FW: FAO Hebe Smith - Snetterton, West Walberton Lane, Walberton, West Sussex. BN18 0QS - SURFACE WATER DRAINAGE WA/11/25/DOC

Re - Snetterton, West Walberton Lane, Walberton, West Sussex. BN18 0QS - SURFACE WATER DRAINAGE WA/11/25/DOC

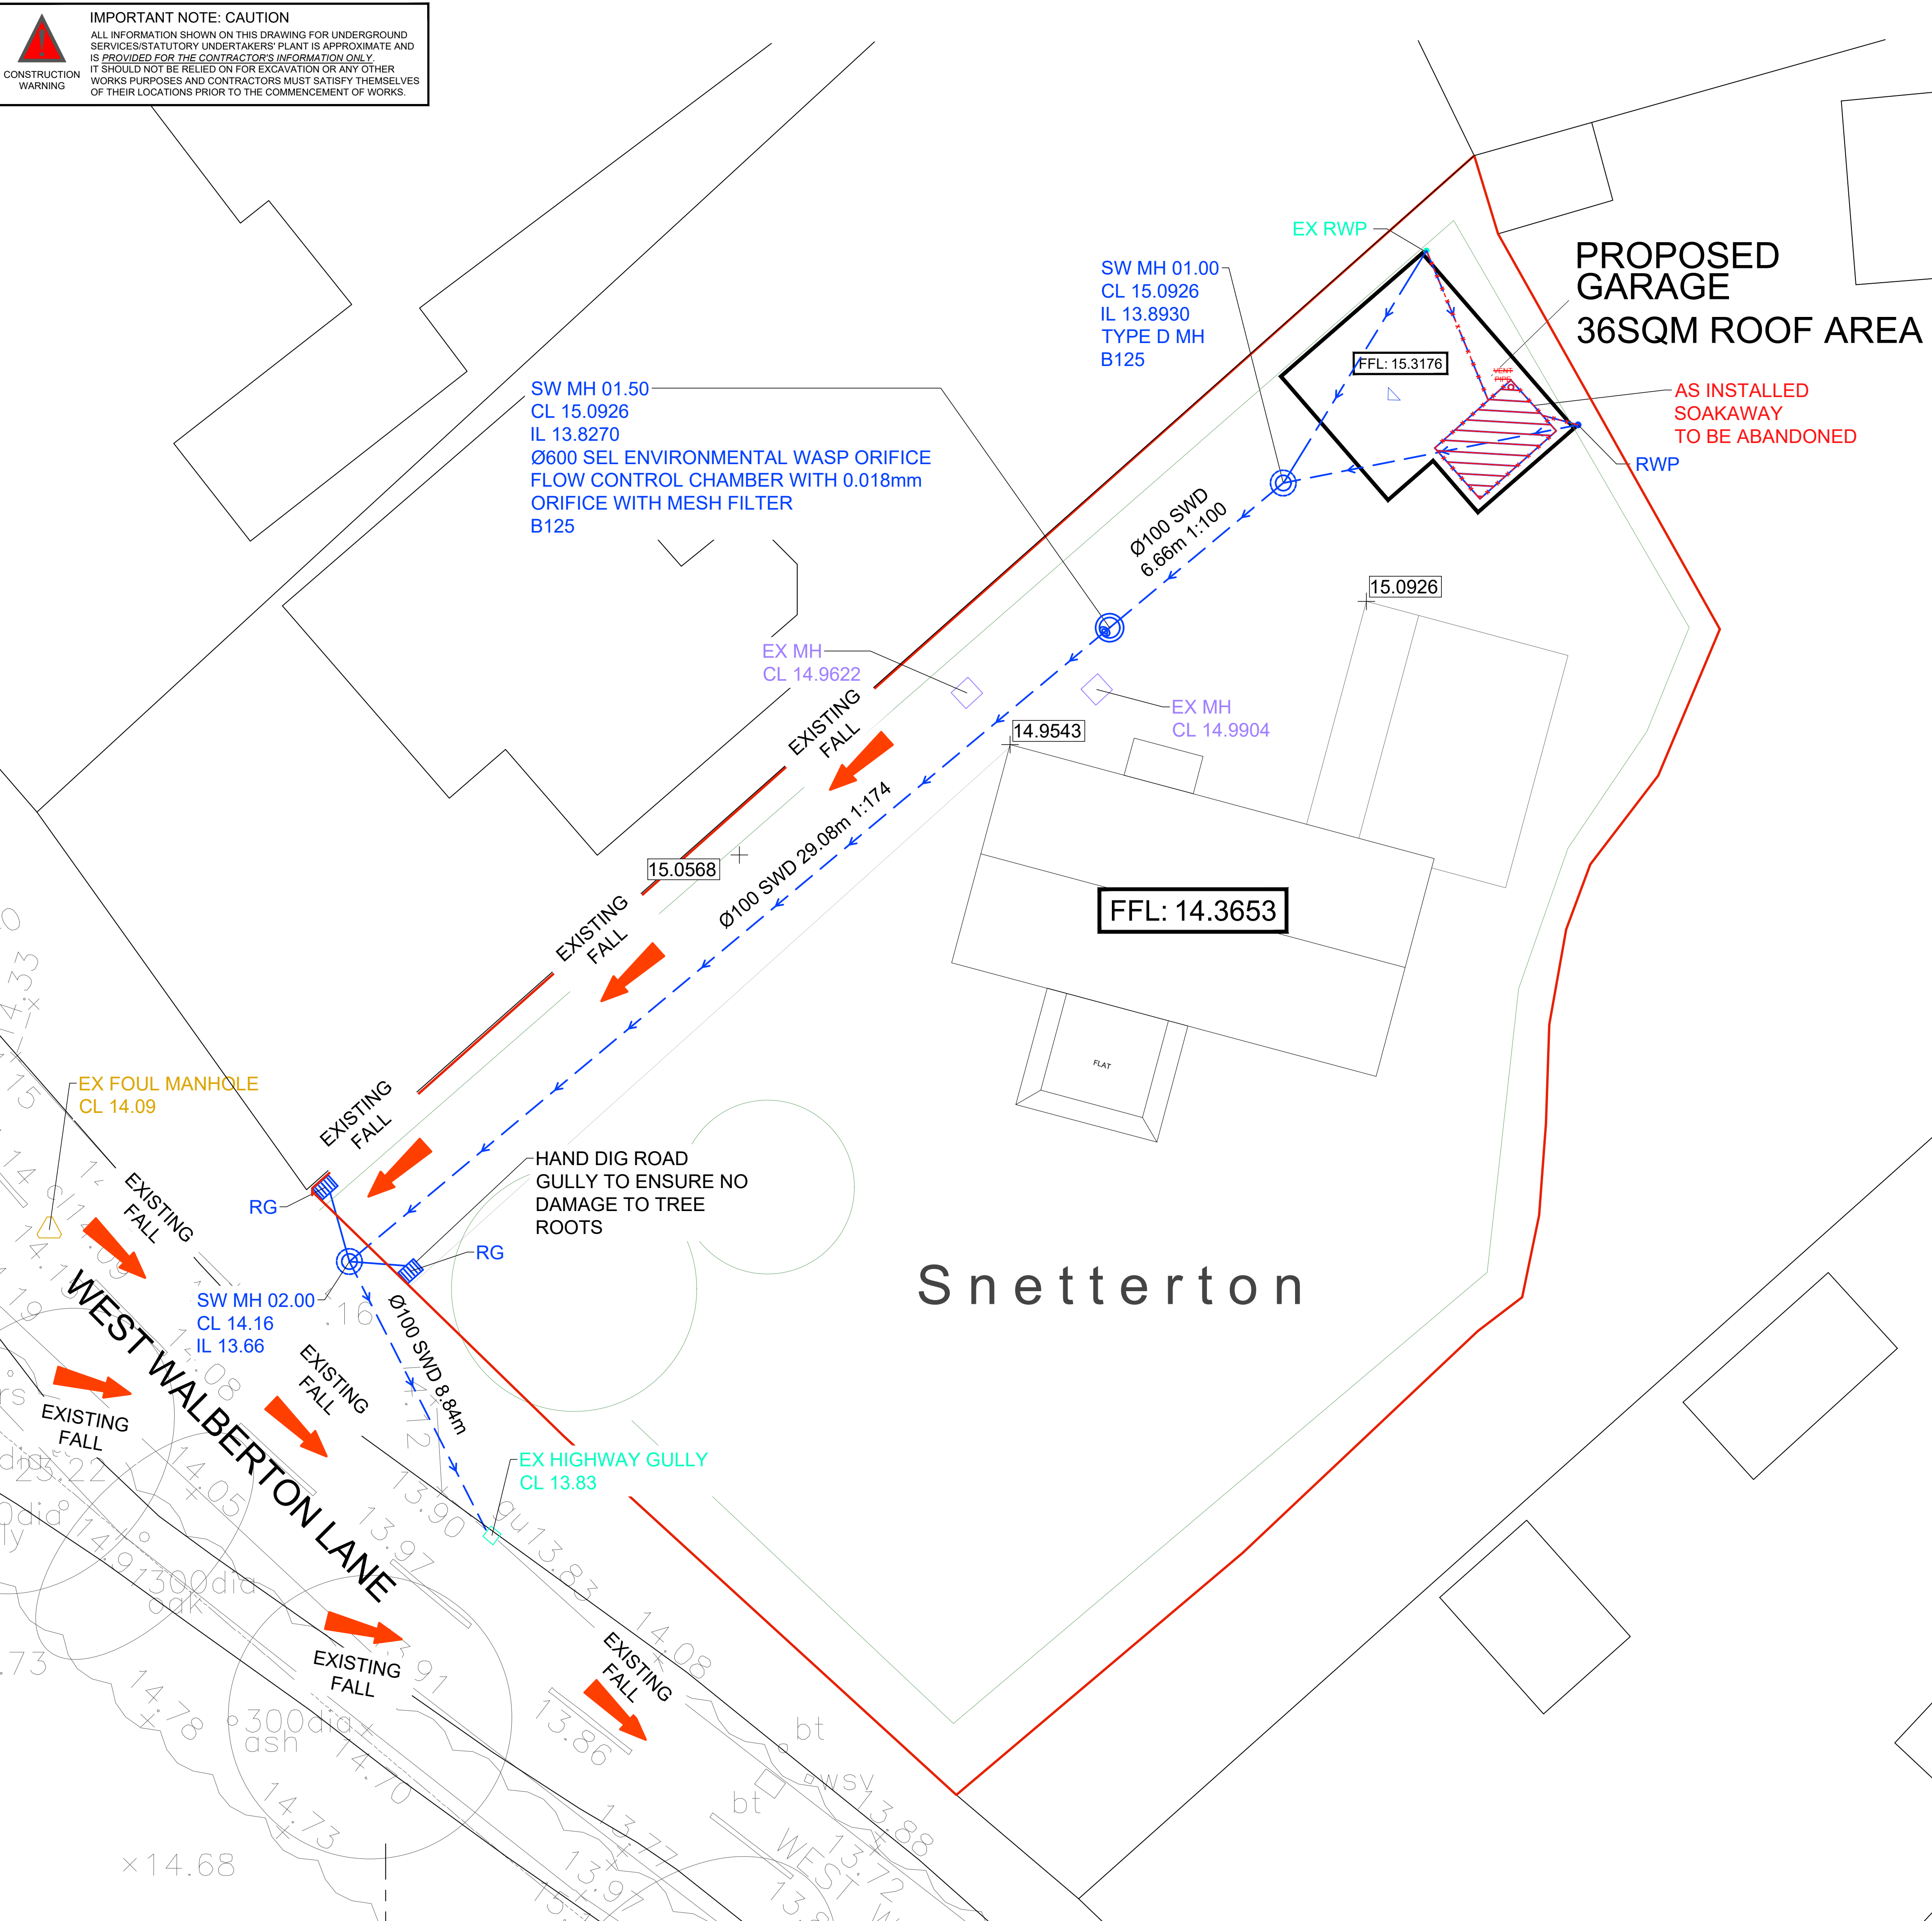
Following the redesign of the pipework/chamber arrangements downstream of SW MH 02.00 it is necessary to model the networked system up to the replacement catchpit gully in West Walberton Lane – please revise accordingly.

The surcharge level/depth should reflect the cover level at this location ie. 13.830.

Flooding on a 1 in 30 event is not acceptable and must be retained below ground.

Any flooding resulting from a 1 in 100 year event must be retained on site. Based upon the modelling and topography, this is not being achieved, as excess water would flow onto West Walberton Lane.

It is clear that the applicant needs to reconsider their design to ensure that the 1 in 30 year event is stored below ground and the 1 in 100 year event does not flow off site.

EX HW RG Added to Model

EX HW RG used as surcharge point

Additonal storage provided in the form of a 1200 dia WASP manhole rather than 600 dia and pipework upsized to 300mm dia to ensure no flooding for the surcharged scenario
